BOTLEY WEST SOLAR FARM

OXFORDSHIRE HOST AUTHORITIES RESPONSES FOR DEADLINE 4 | FRIDAY 22 AUGUST 2025

RESPONSES FOR DEADLINE 4

The purpose of this submission is to provide written confirmation of the OHA’s comments and response on documents submitted at Deadline 3 (**D3**) and the applicant’s draft Accompanied Site Inspection (**ASI**) itinerary and an update on draft statements of common ground (**SoCG**).

Map 1 Important Views in Cumnor Parish

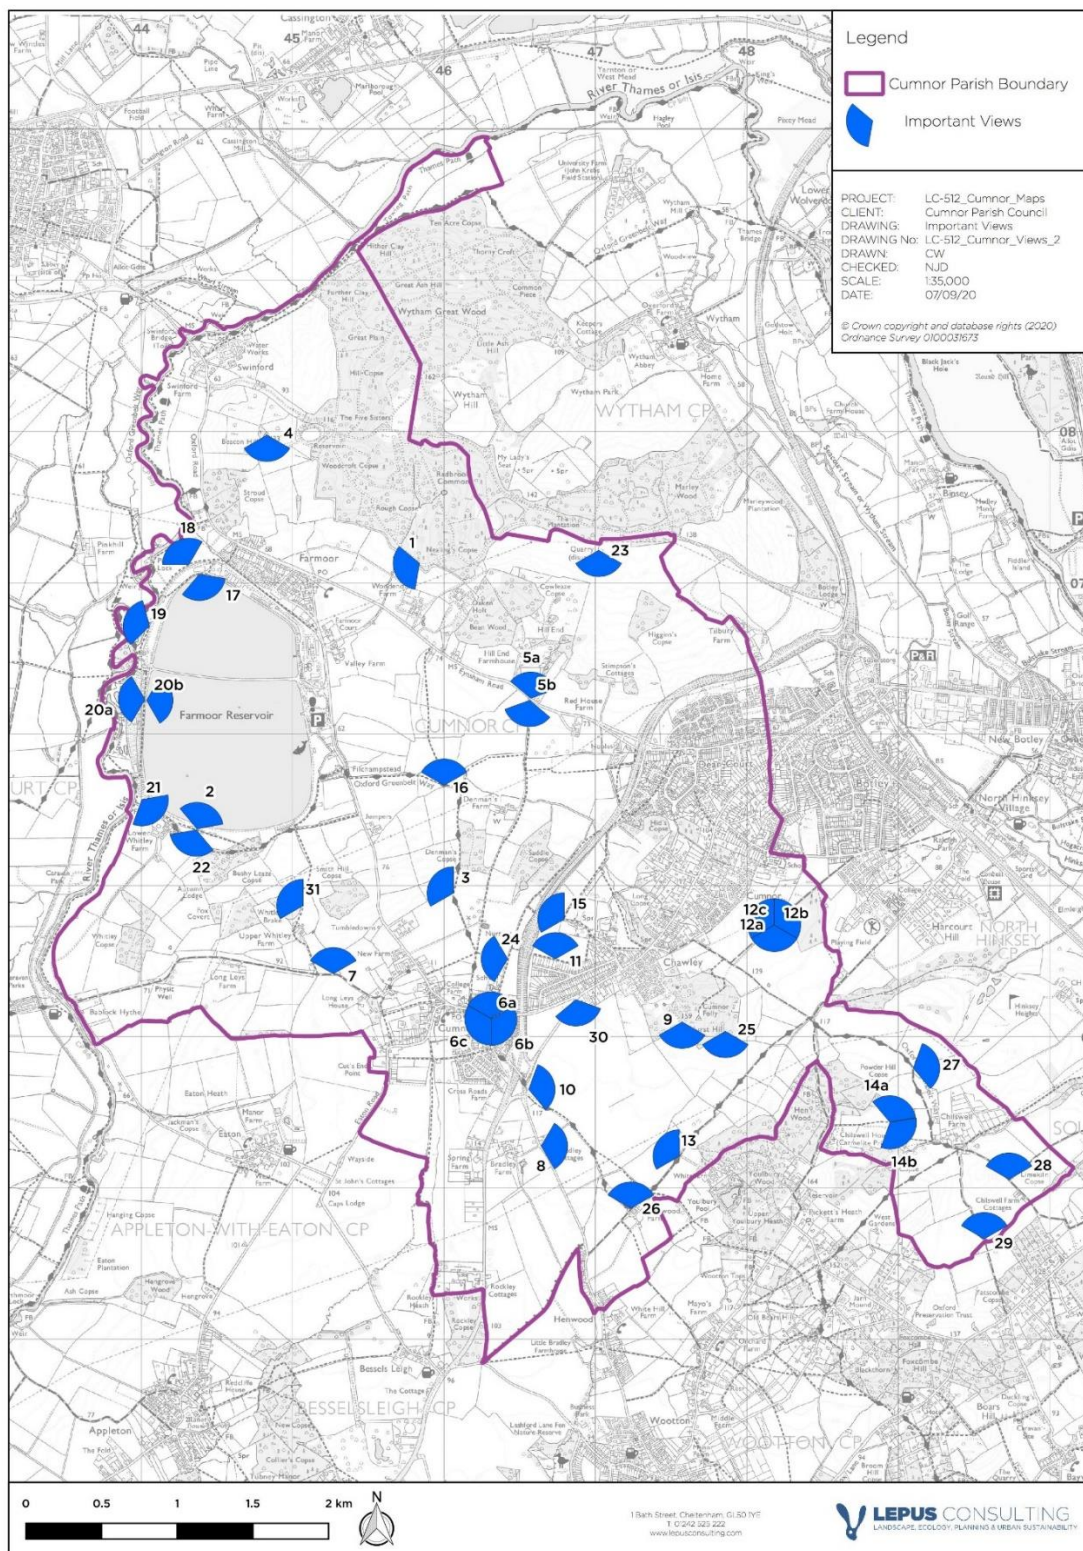
VWHDC – The applicant response does not address the point on the omission of key views cited in the Cumnor Neighbourhood Plan.

VWHDC recommend the suggested locations from Ben Prior [AS-043] and Bill McGill [REP2-088] are visited. The ExA is also recommended to visit the locations listed by Cumnor Parish Council [REP2-047] that are designated as Important Views in the Cumnor Neighbourhood Plan.
